Technical Note

Project No: ITB14224
Project Title: Nursery Fields
Title: ITB14224-015
Ref: LHA and PROW Response
Date: 25 February 2021

- 1.1 Landform Bersted Ltd (Landform) has submitted a planning application to Arun District Council (ADC) for 225 new homes on land to the north of Chalcraft Lane known as Nursery Fields (planning ref: BE/148/20).

APPENDIX 5
SITE ACCESS PLAN (REF: ITB14244-GA-009B)

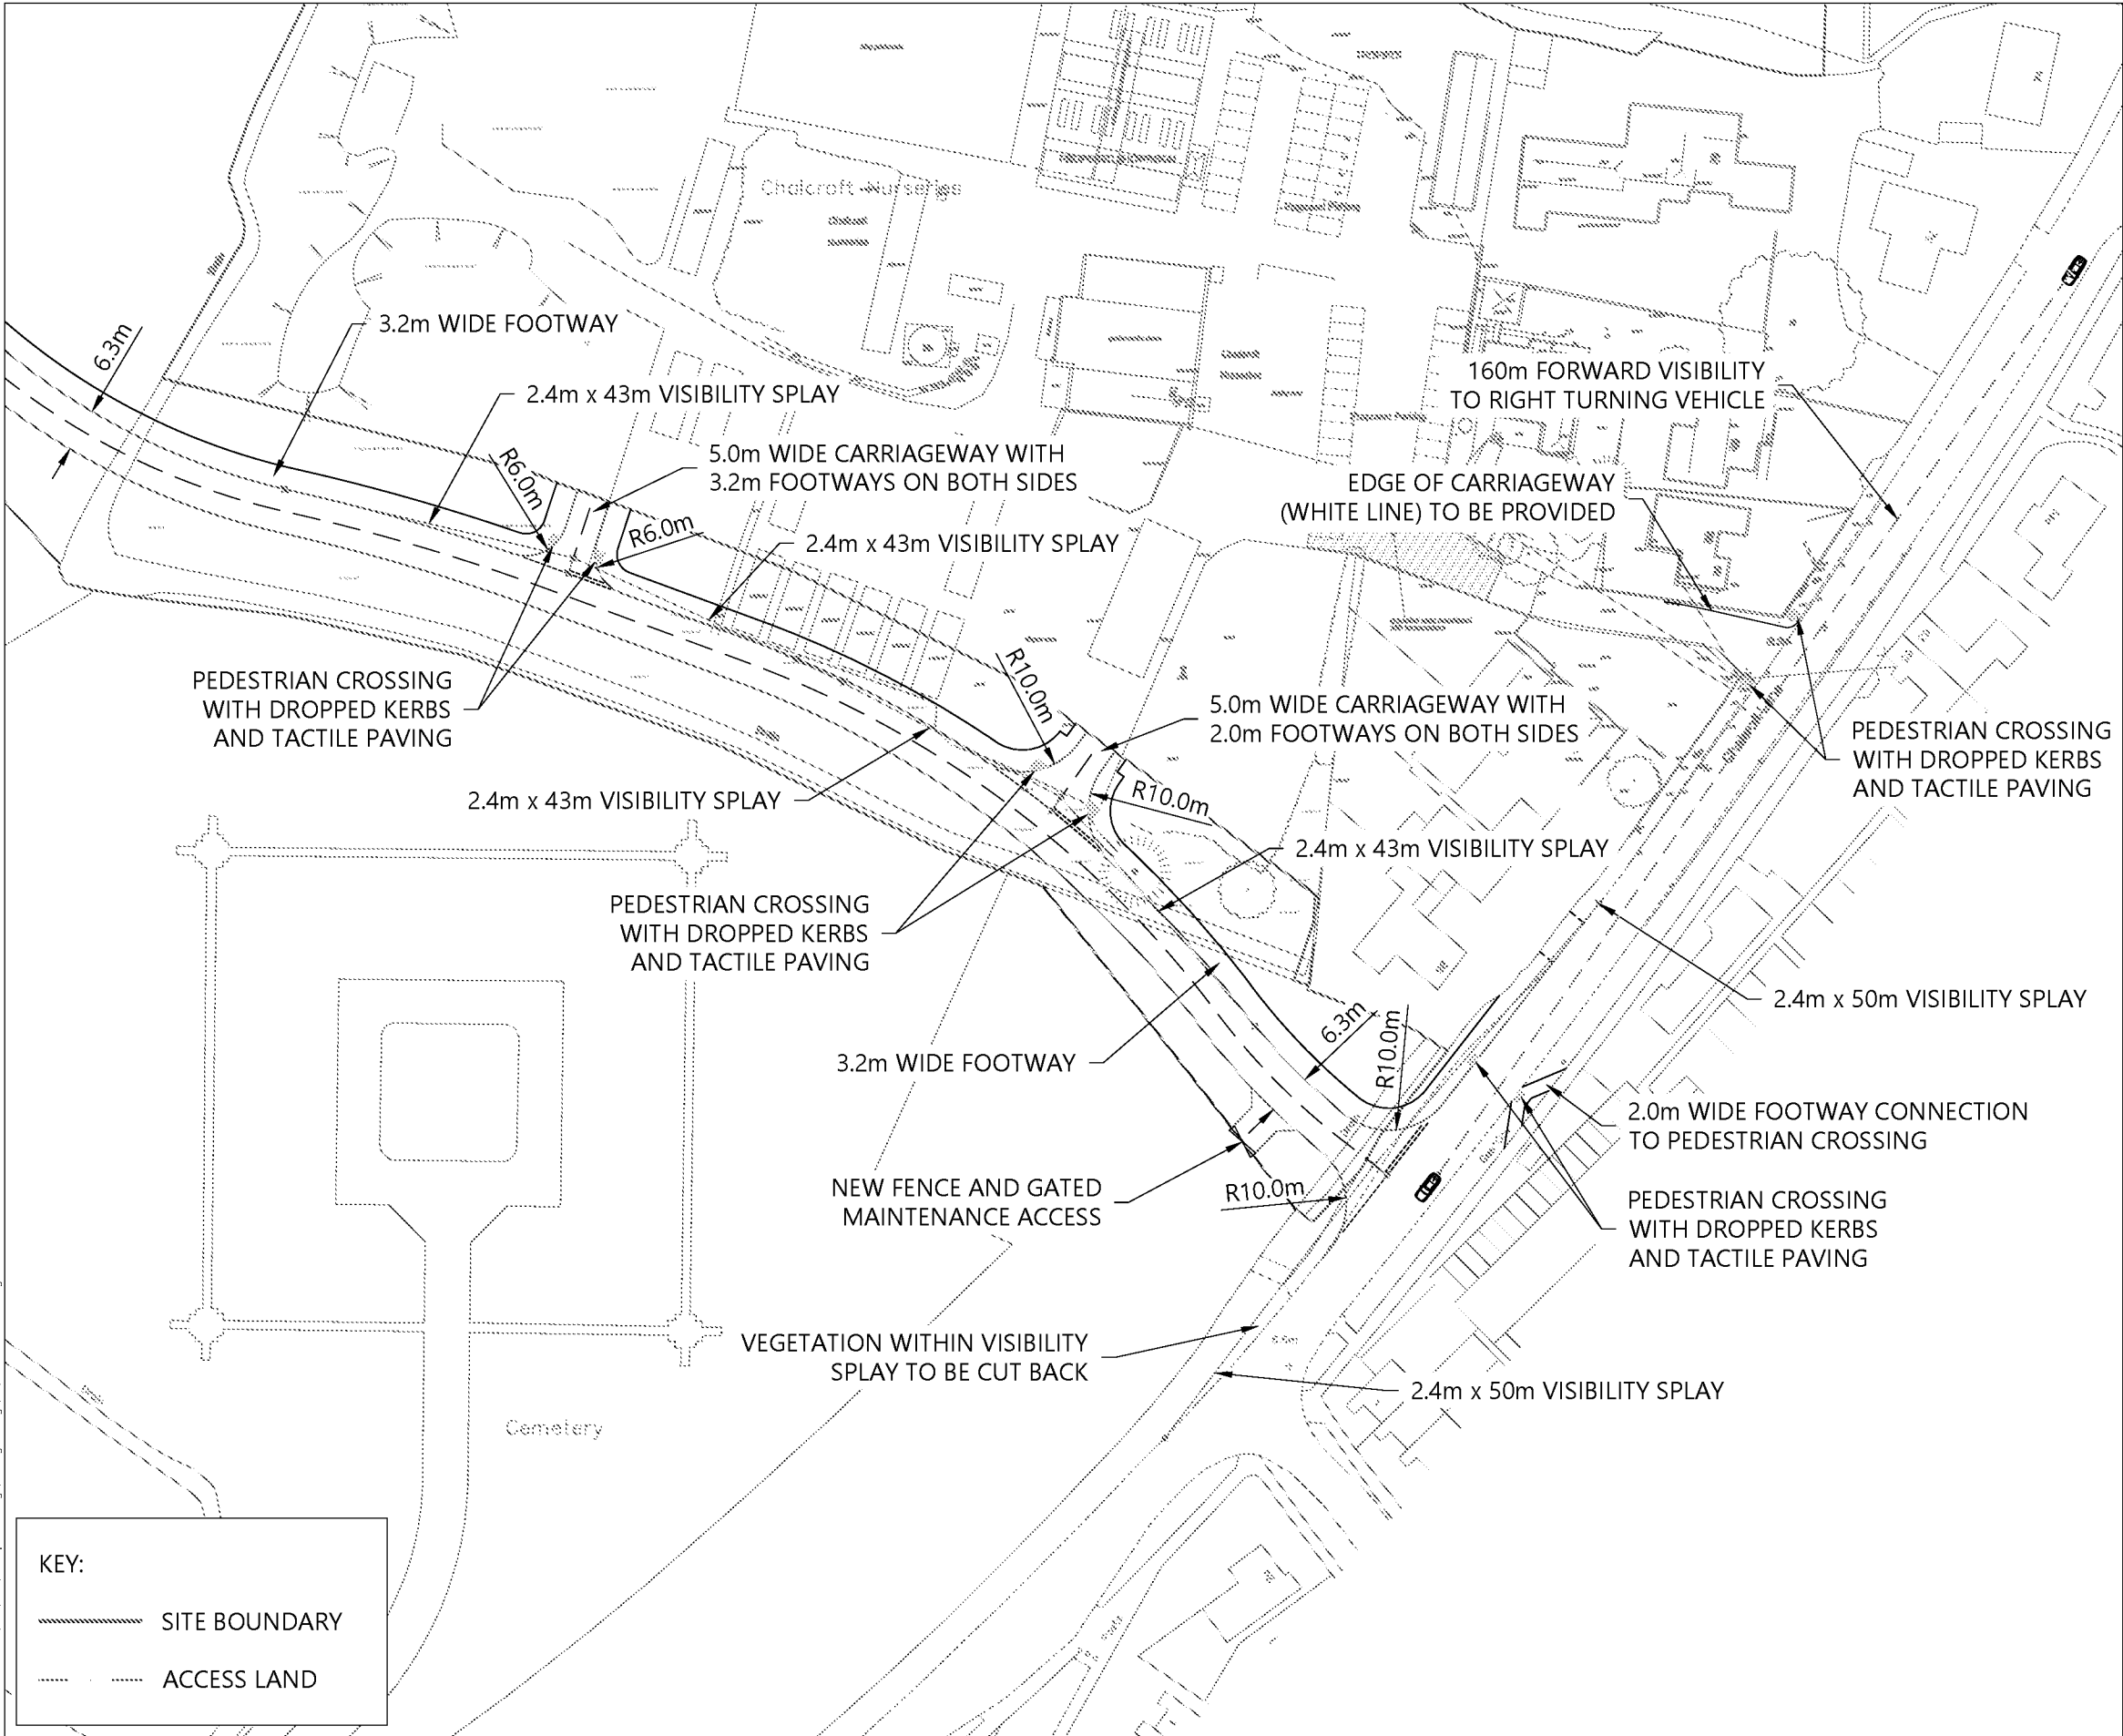
- 2.4.1 WSCC has requested that the cycle infrastructure adjacent to the site access road and the associated infrastructure along Chalcraft Lane (including a Toucan crossing) is removed, focussing cycle access

towards the community centre access road and existing cycle infrastructure along this corridor towards Bognor Regis.

- 2.4.2 The site access drawing has been amended to reflect these amendments and the revised arrangements are presented as **Drawing ITB14224-GA-009 Rev B**. Similarly, the Land Use Parameter Plan and the Green Infrastructure Plan have also been updated and copies of these are provided at **Appendix C**.
